Subject: Comments on planning application ref: FG/184/21/PL - 1 Greenways Crescent, BN12 5EF

We object to the proposed plans at 1 Greenways Crescent for the following reasons:

Figure 3: Existing and proposed west elevations

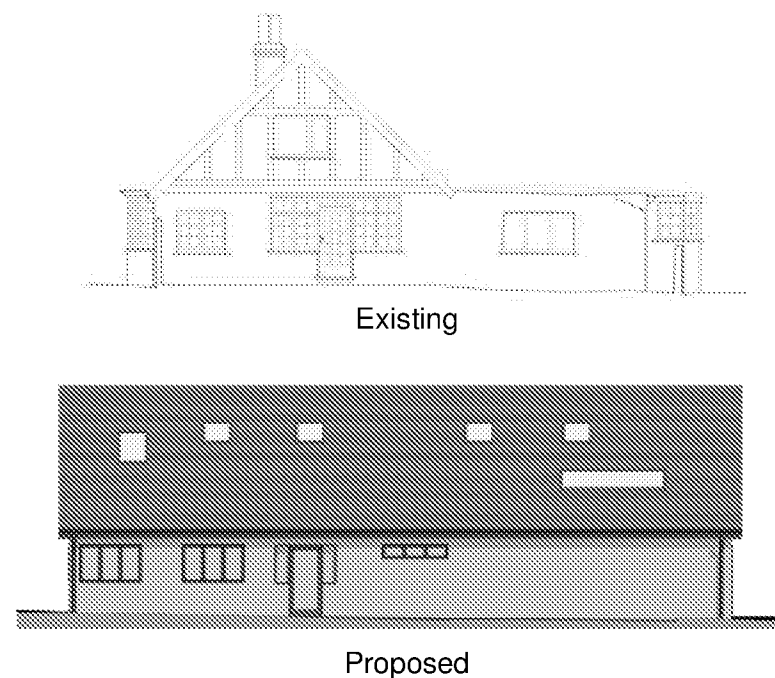
- 3) The proposed west-facing ground floor windows would protrude beyond the existing boundary fence between numbers 1 and 2, thereby impacting upon the privacy of numbers 2, 3, 4 and 5

Figure 4: Existing and proposed north elevations

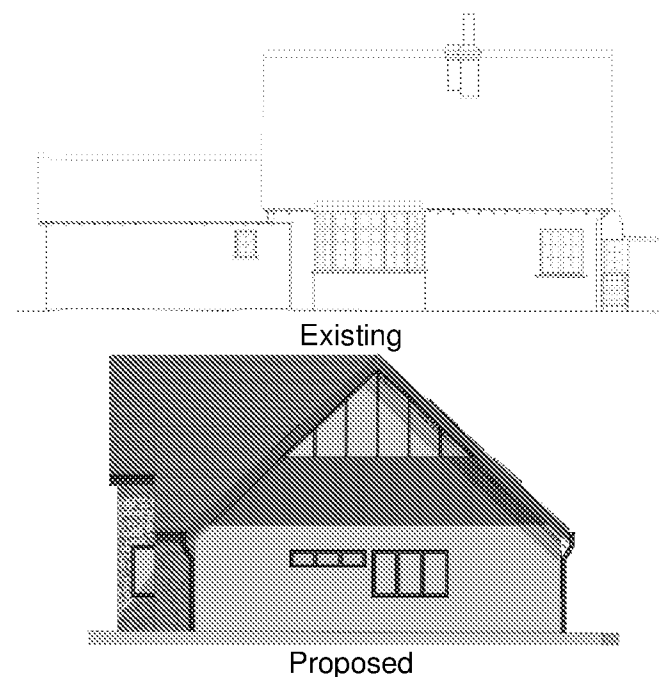
- 1) The proposed northern elevation of the new house will be considerably closer to the road. Greenways Crescent is a relatively narrow lane and my view is that the new house will be overbearing, and have an adverse visual impact on the whole of the street, especially considering that all the other houses are set back from the road

- 2) The upper story gabled window on the northern elevation of the new house would be severely detrimental to the privacy of number 7, directly overlooking both their lounge and main bedroom

Figure 7: Proposed garage

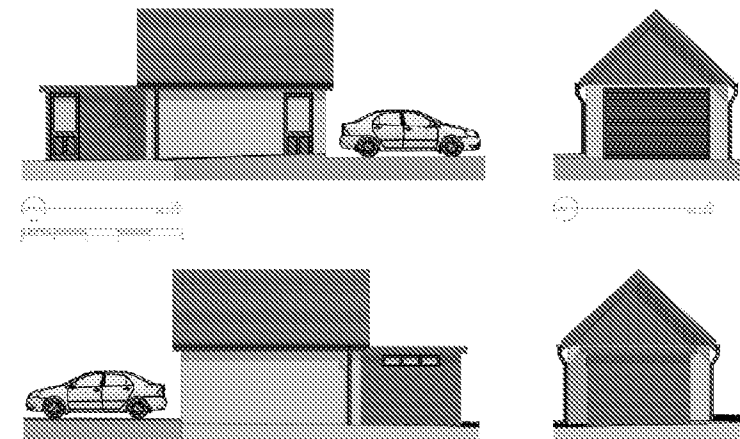
- 4) Moving the proposed new house closer to the road will result in some loss of morning light to the front gardens of numbers 2, 3 and possibly 4
- 5) The proposed height and pitch of the garage would be significantly overbearing to the rear of number 2.
